MITCHELL SHORT PLAT
FILE NUMBER SP-17-00003

Preliminary Approval Condition(s)	Applicant Response	Staff Review
Critical Areas		
1. Future building on Lot 1C shall be located a minimum of 100 feet landward of the OHWM of the identified streams as shown on approved site plan for Lot 1C.	Added note on sheet 1.

NANEUM ROAD SHORT PLAT

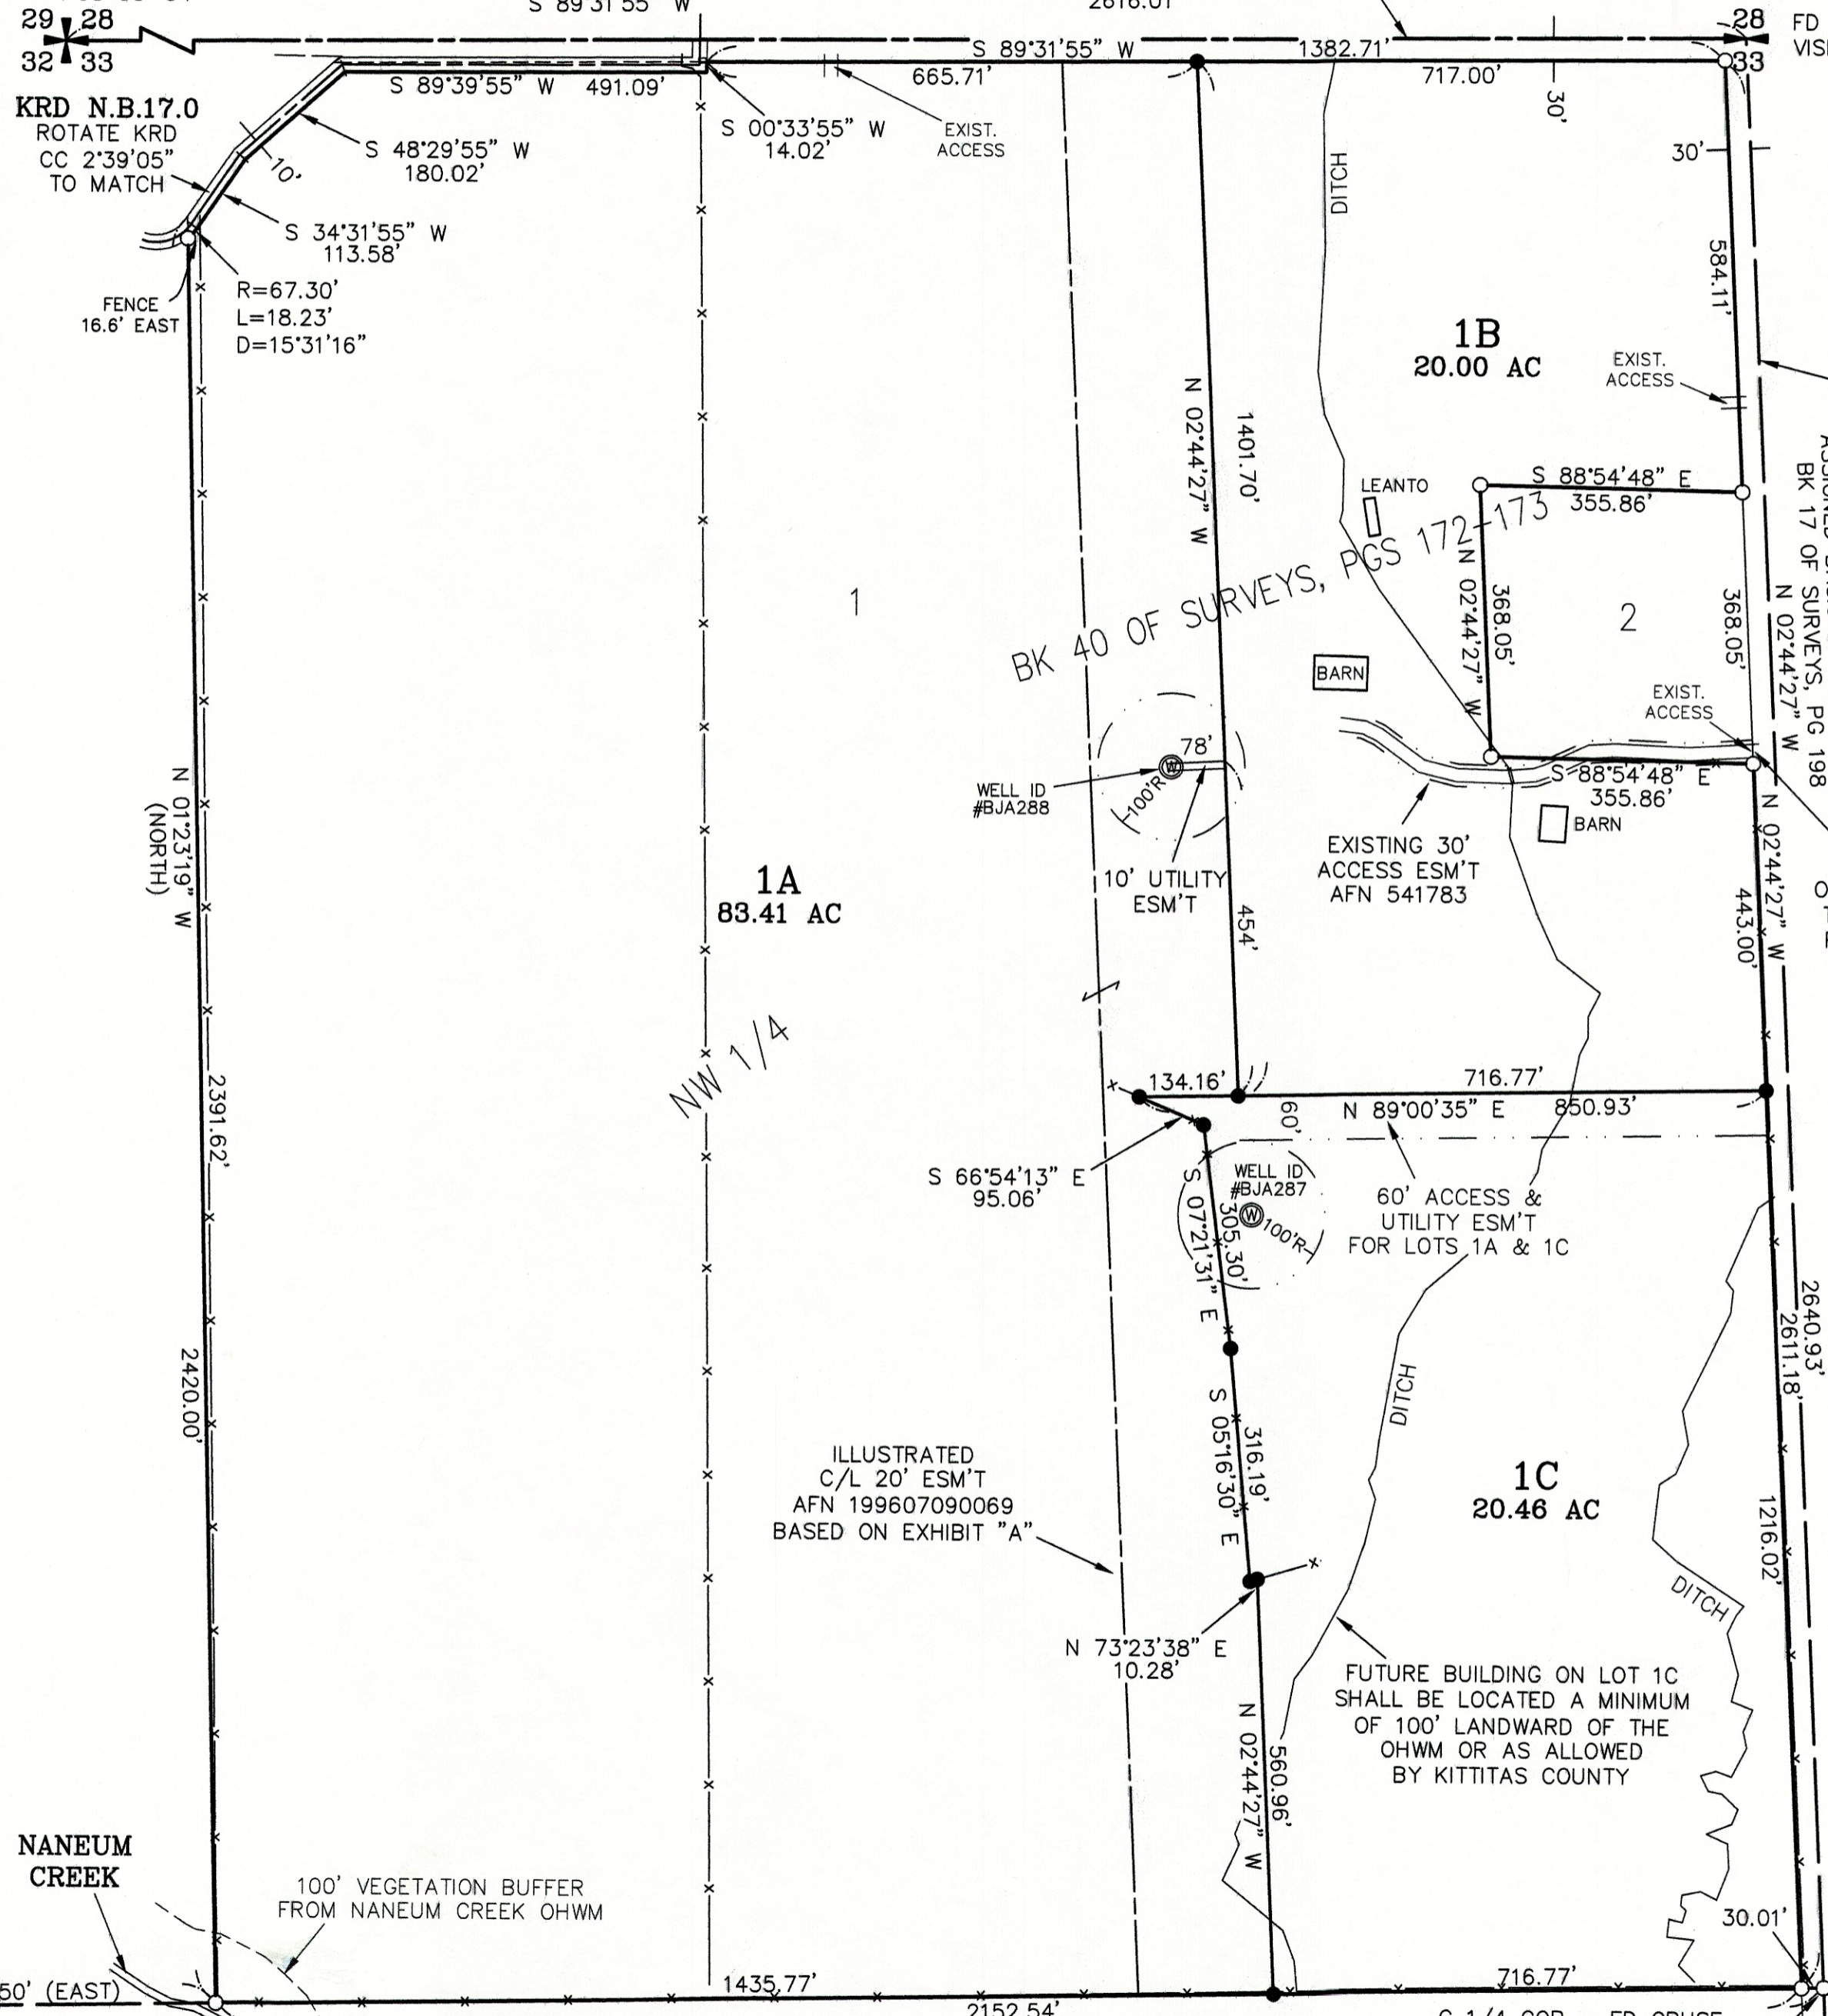
2. Naneum Creek shall be delineated on the final mylar and indicate the 100 foot buffer from the OHWM.	Added setback to sheet 1.	
Water/ Sewer		
3. Proof of water adequacy including a well log or 4 hour draw down test, and a mitigation certificate for each proposed lot shall be submitted to CDS prior to final approval.	Well log and draw down test included. Mitigation certificate submitted with final plat.

4. Final Mylars shall be marked with a "w" indicating location of the well and a broken line showing the one hundred foot radius around such.	Added to sheet 1.

5. All wells must meet the distance requirement of 50 feet from the property line, 50 feet from the septic tank and 100 feet from the drain field as per Kittitas County Critical Areas Ordinance 17A.08.25, and KCC Chapter. If existing wells do not meet the setback requirement from property lines, the two adjoining parcels nearest the well must enter into a legal, shared well-users agreement.	Added to sheet 1.	
Roads and Transportation

6. Access to Lot 1B: A 30' joint access easement for Lot 1B snf	Added to sheet 1.
